## Response to a State Significant Development

Bowdens Silver - Development of an open cut silver mine and associated infrastructure at Lue (SSD-5765)

27 July, 2020.

Figure A7.1 | Final Land Uses

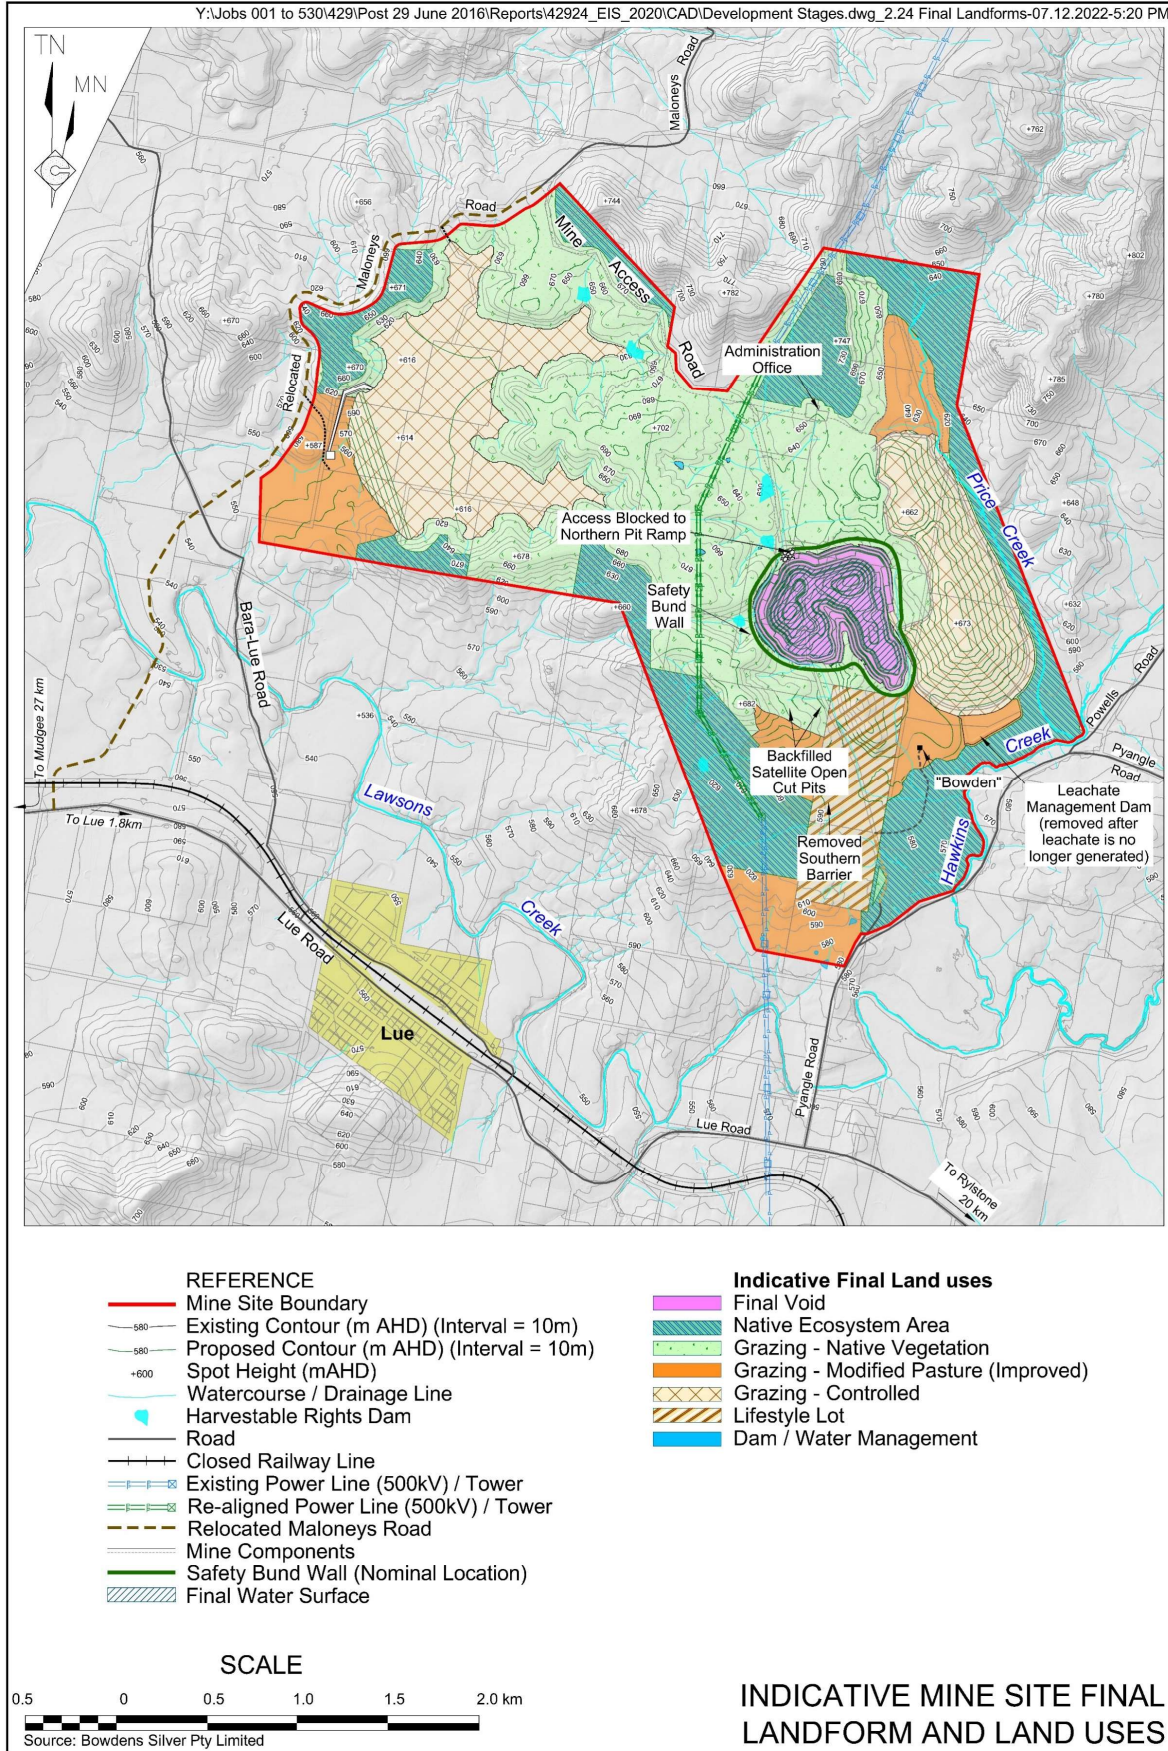
- Mine Void 53Ha will remain after mine closure
- Waste Rock Encasement (WRE) is to be covered and sealed.
- Leachate management dam rehabilitation not clear, will something remain to contain leachate from WRE
- TSF remain as a self-draining landform, does this mean it will continue to provide leachates to Lawsons Creek catchment after mine closure (EIS P2.91 & fig 2.26 p2.92)

Recommendation – the mining lease be rejected.
